**DAVIS RANCH**  
**9350 ELBERT ROAD**  
**PEYTON, CO 80831**  
 PROJECT NAME:  
 PROJECT ADDRESS:  
 PROJECT DESCRIPTION: SKETCH PLAN

SHEET TITLE:  
**SKETCH PLAN**

SHEET NO.  
**SKP1.1**

# DAVIS RANCH SKETCH PLAN

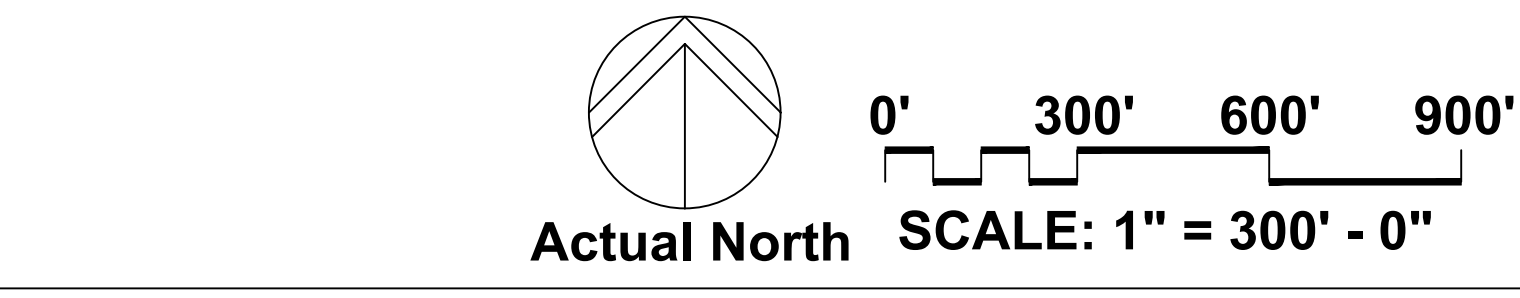
**Final roadway cross sections are not determined at this stage. Please remove.**

**Please be aware that roadway cross sections are not required nor are they decided at this early stage of the development. Recommend that it be removed.**

# DAVIS RANCH SKETCH PLAN

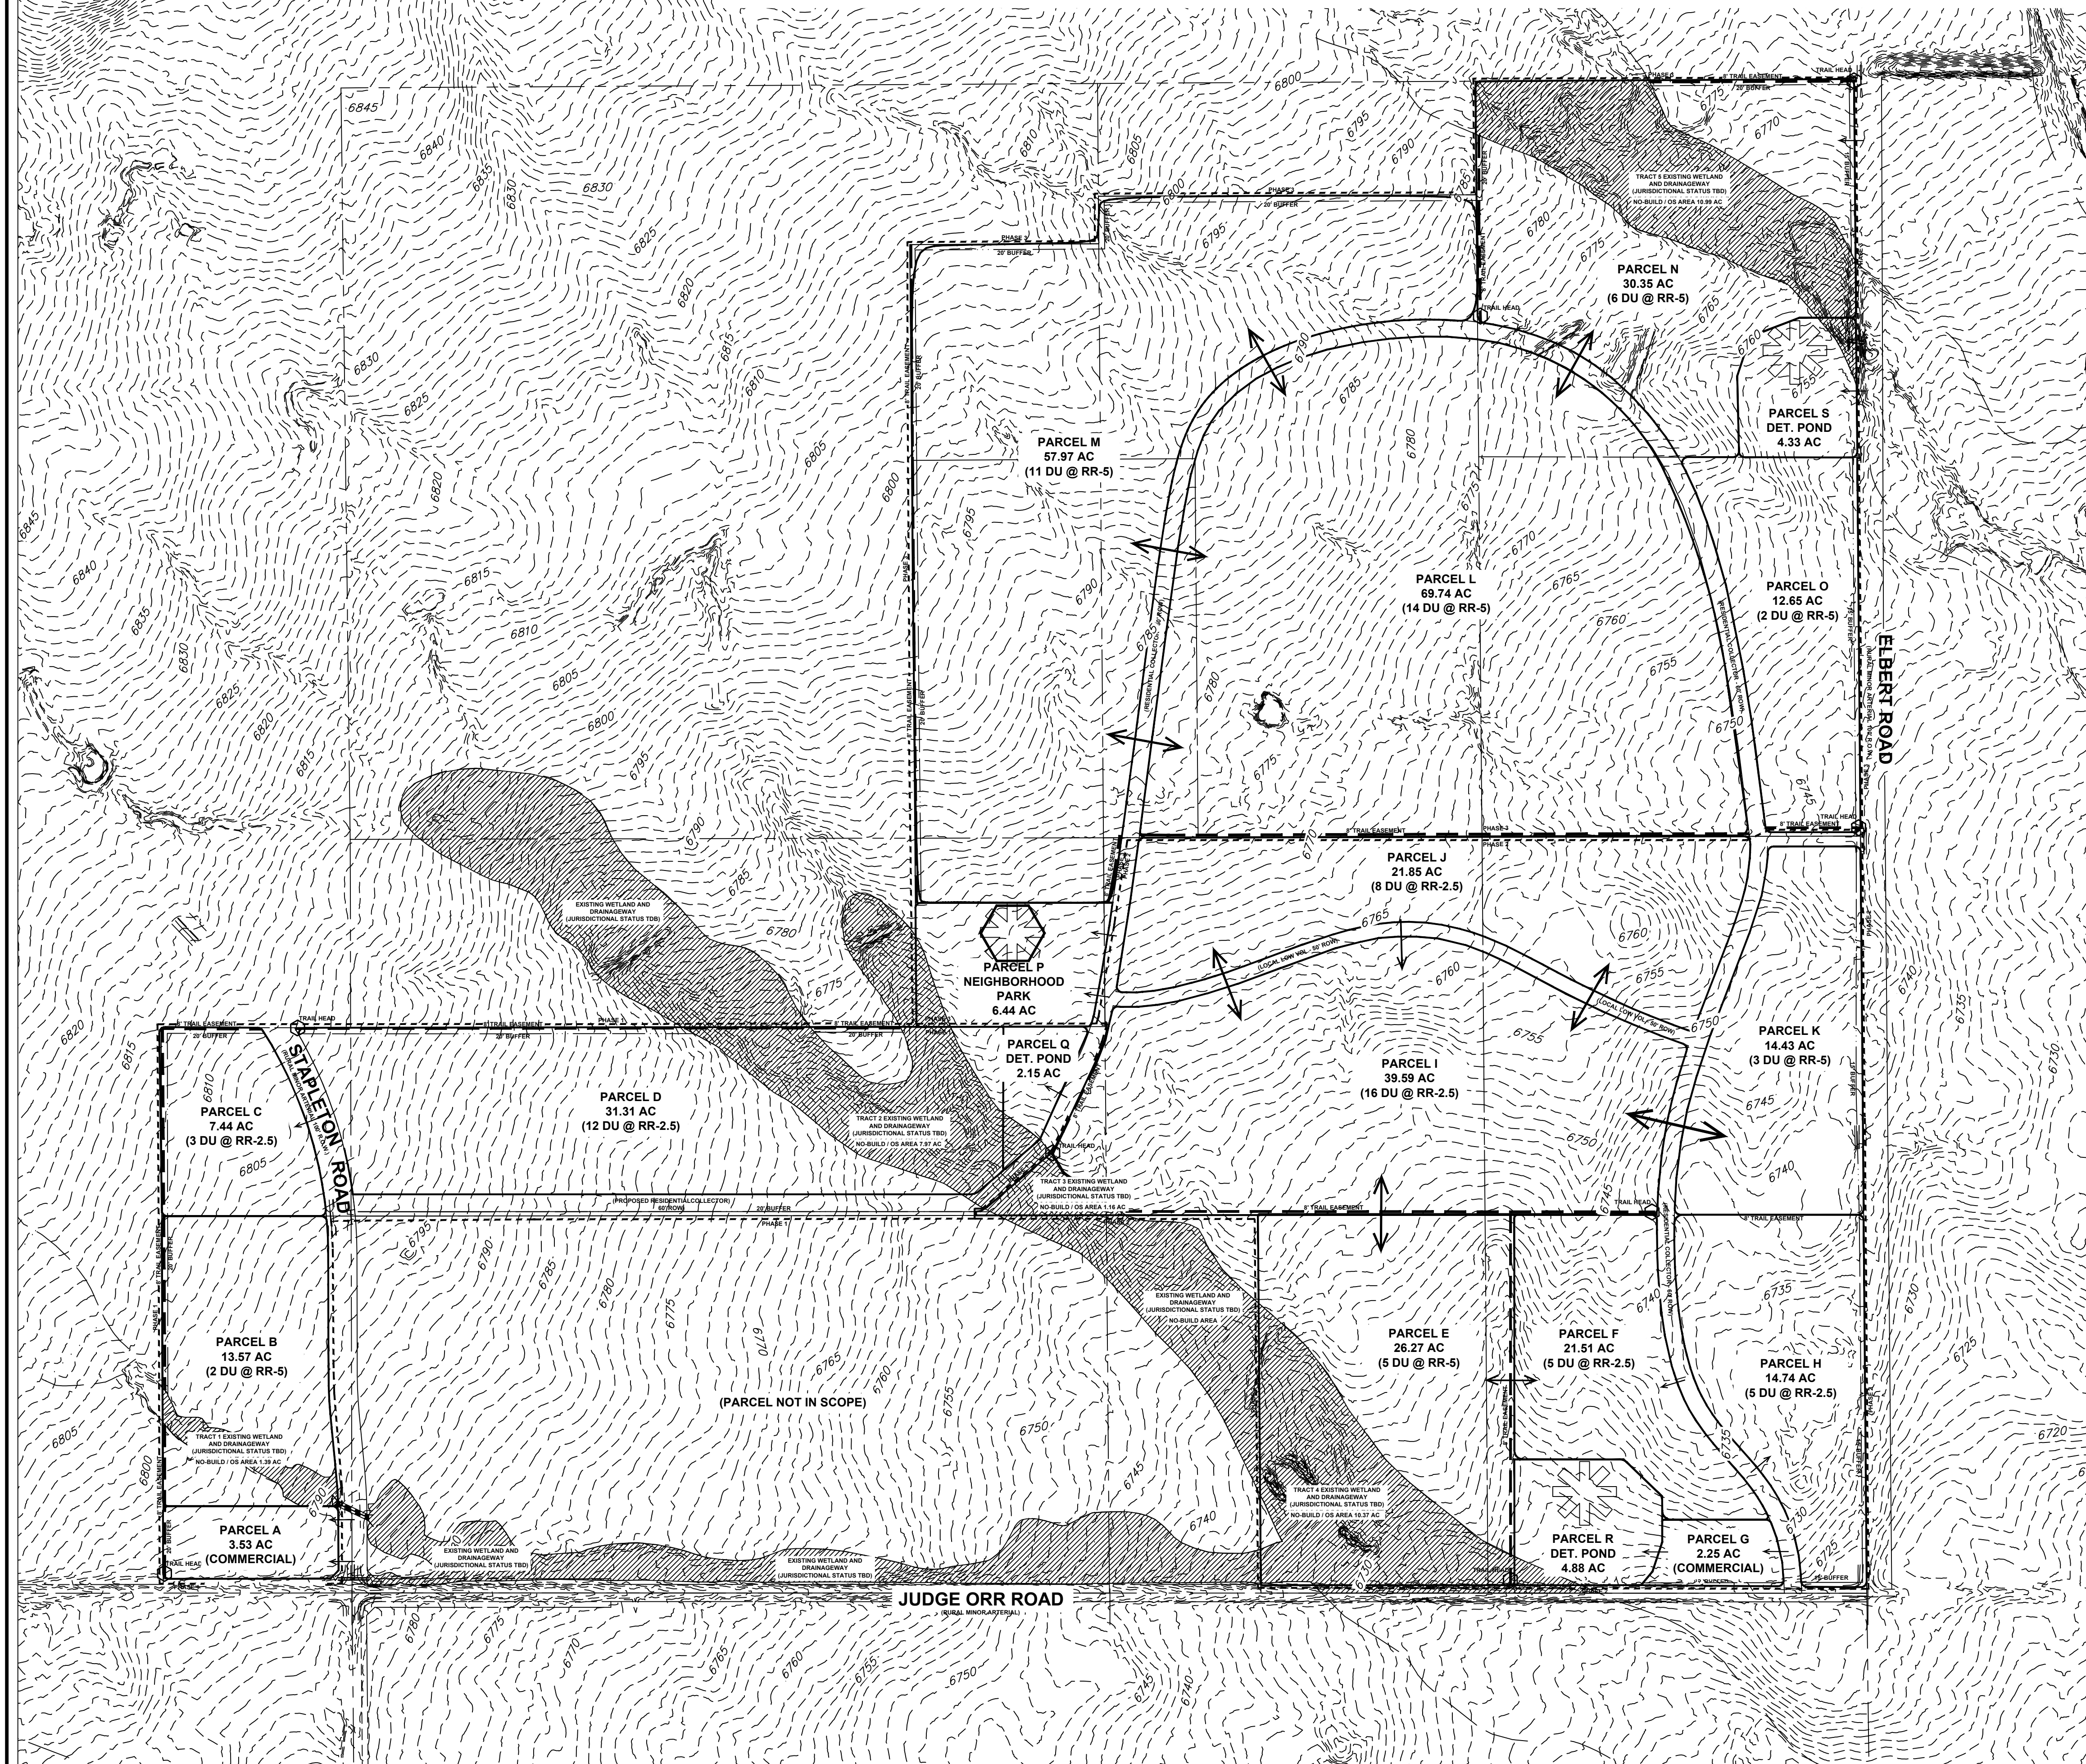
There are ponds shown in the MDDP in both locations this comment identifies. Shown and identify the parcels like the other proposed ponds

These are duplicated
